Your Ref.: 2018/62/90332/W

Please find below our views, objections and concerns re: 'Erection of extensions and alterations to workshop to form one dwelling (within a Conservation Area)'

Rear of 149 Halifax Old Road, Birkby, Huddersfield, HD2 2RW

CLIENT	Mrs Roheena Akhtar				
ADDRESS	29 Aqua Marine Drive Fartown, HD2 1BG				
PROJECT	Rear extension and garage roof conversion				
DRAWING	Proposed elevations				
DRAWN	UH	DATE	Jan 18	SCALE	1.50@A1
DWG No.	1503/03D				
STATUS	PLANNING

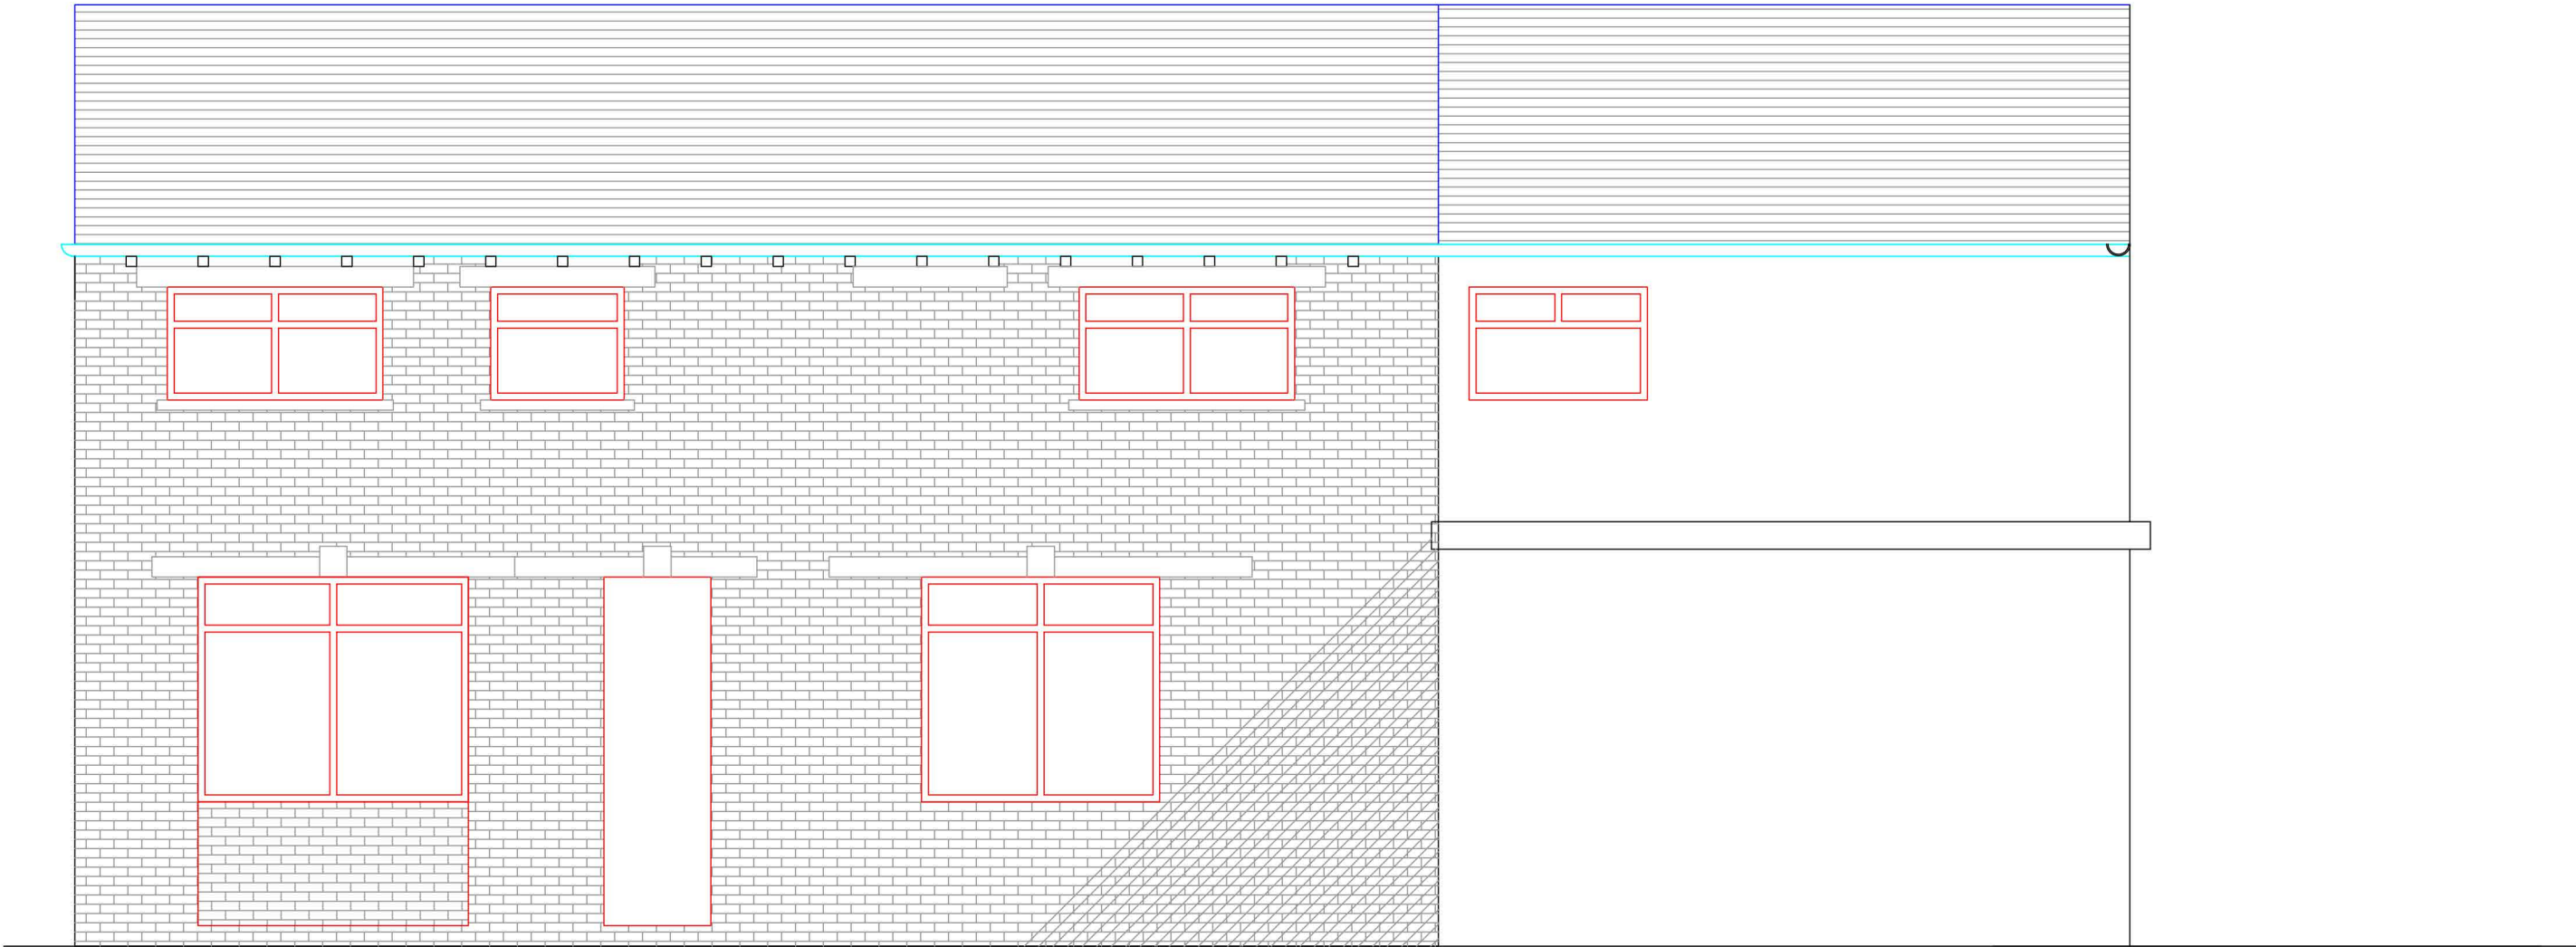
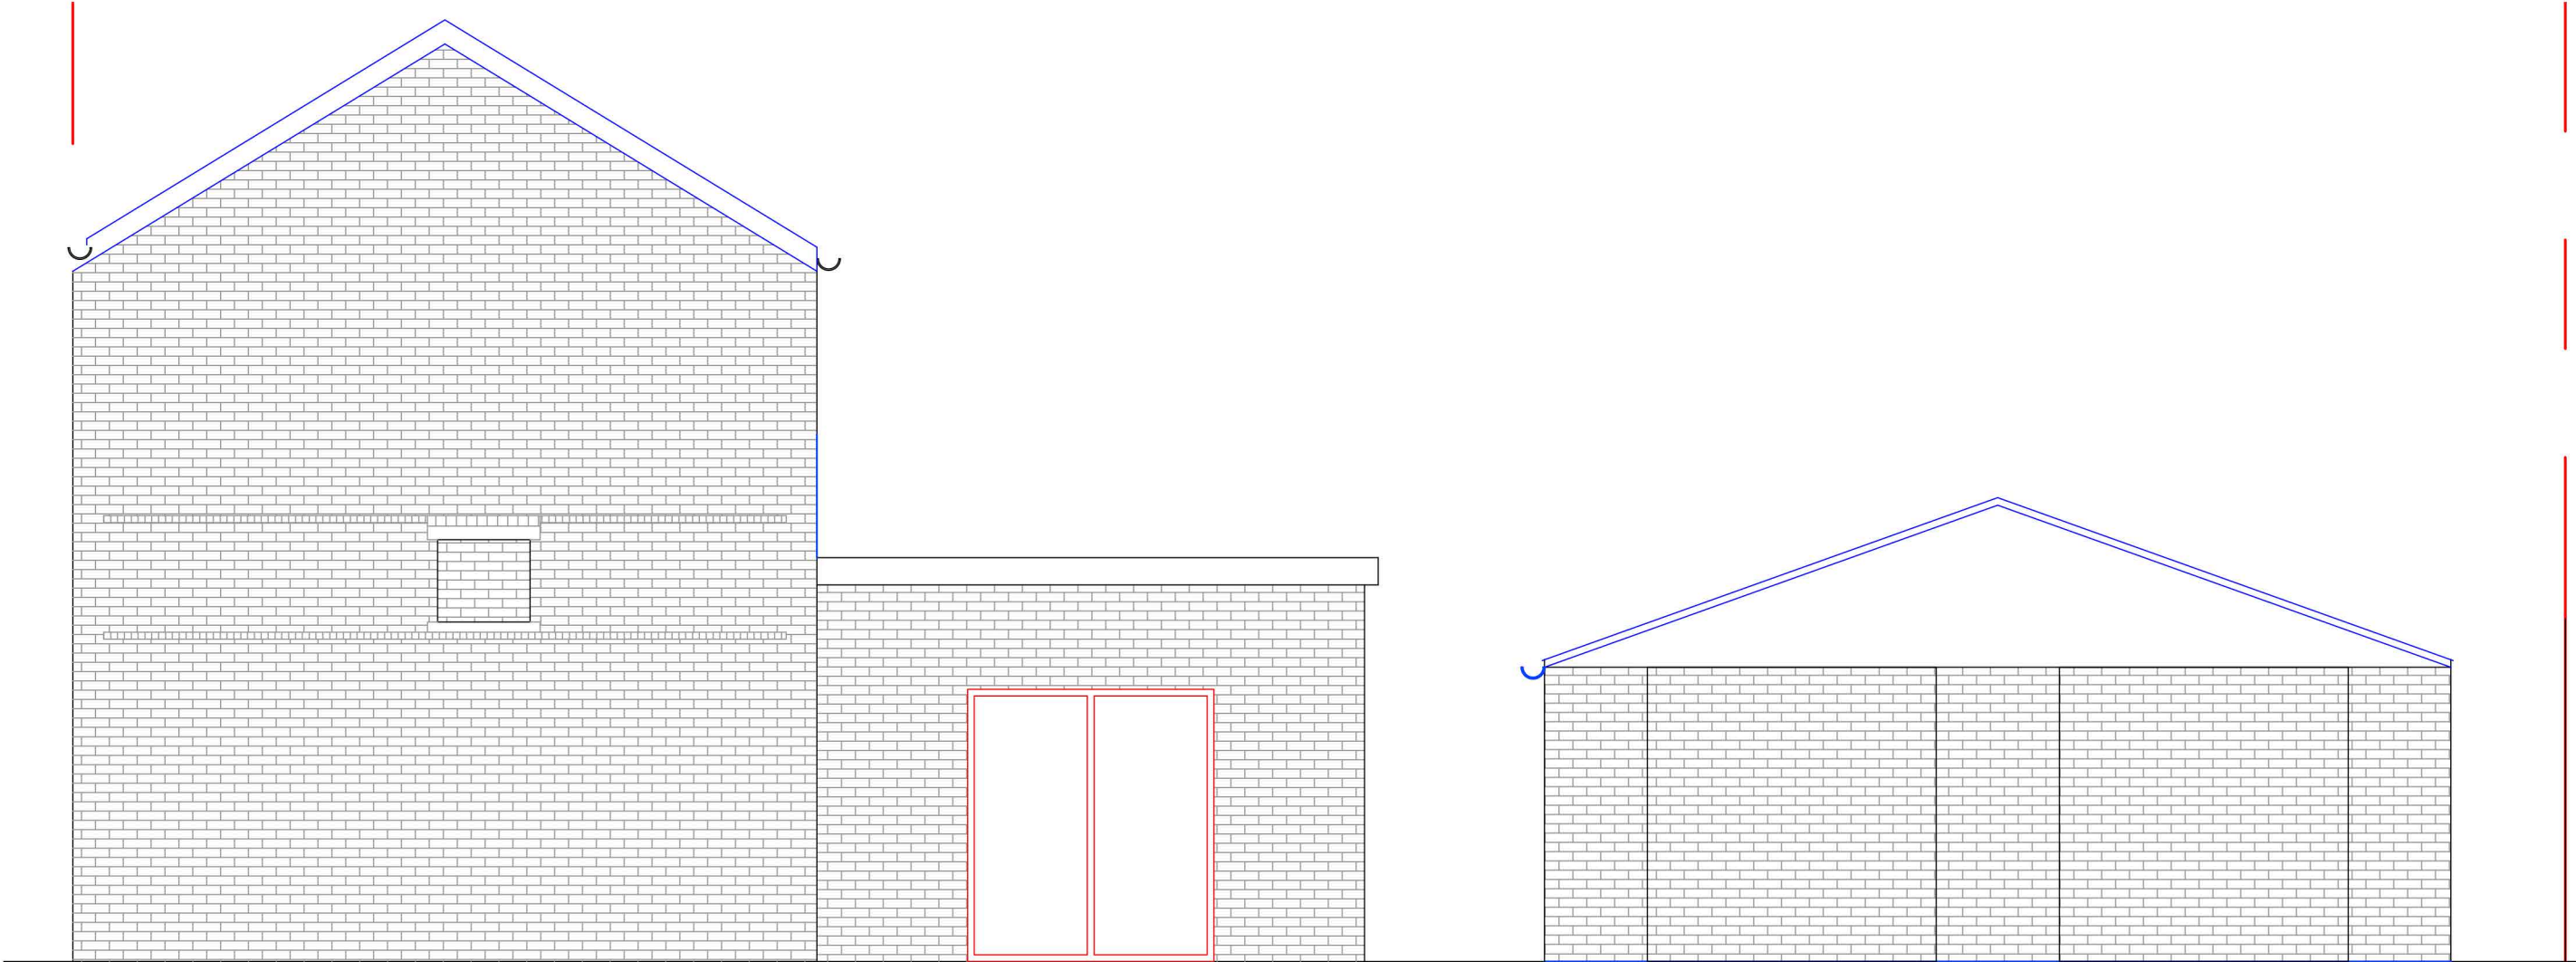
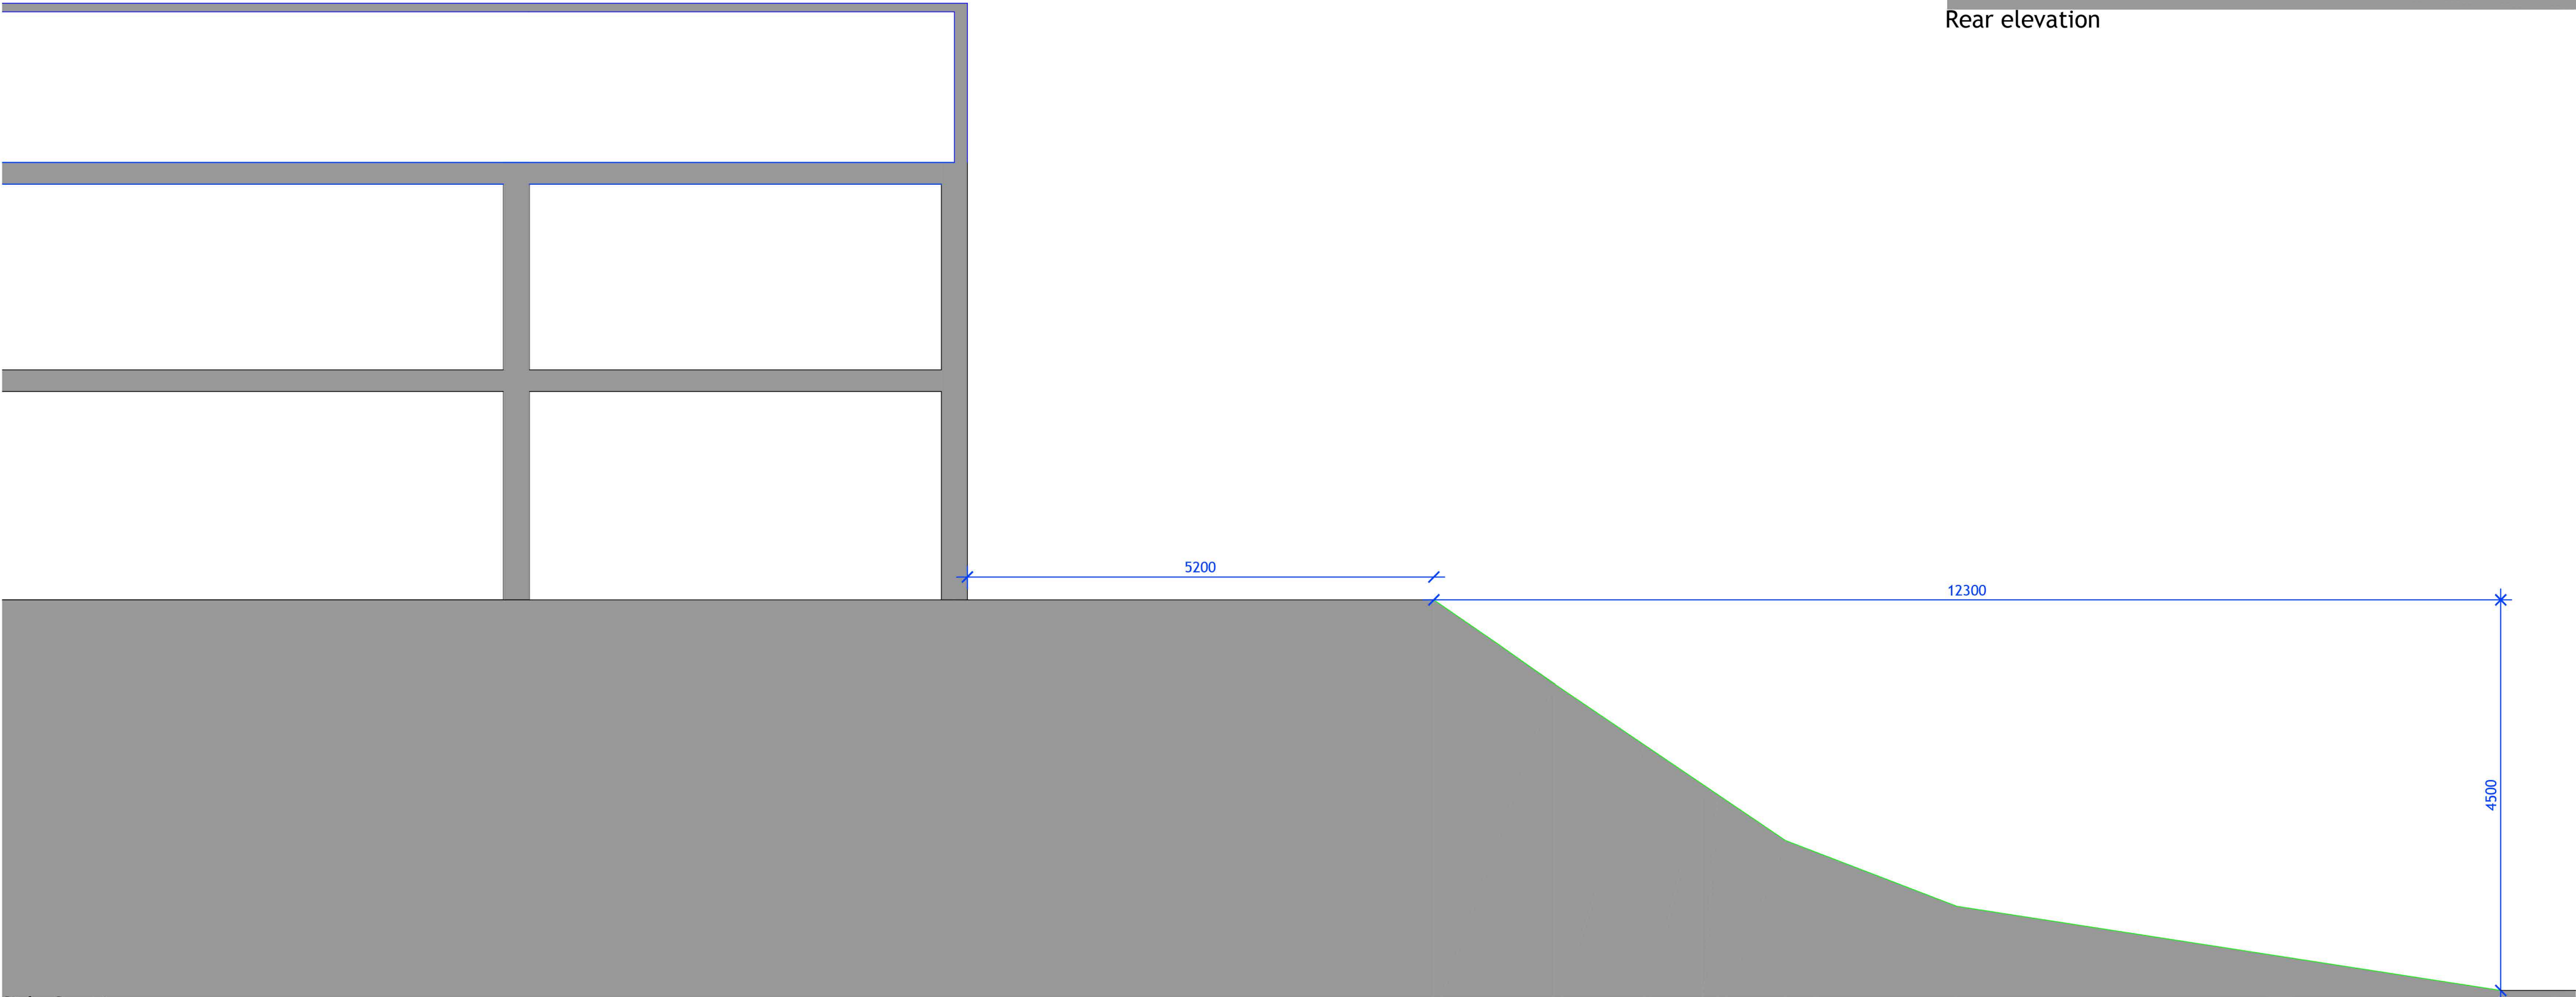
The proposed 'car parking' as it appears on the plan still does not suggest that there will be much space for straightforward access to our garage and car port. We have enjoyed unimpeded clear access in and out of our garage and car port for over 38 years. We notice on the new plan that the area opposite our car port/garden gates has now become the designated parking area. If the parking space is in use, we have a concern that we will not have unhindered access to our property and will require someone being available to move parked vehicles etc. The car parking requirements as they are now shown for the development would still prevent the free unhindered egress of our car from our garage and also parking in our back garden car port for other family members. This would impact on our family,
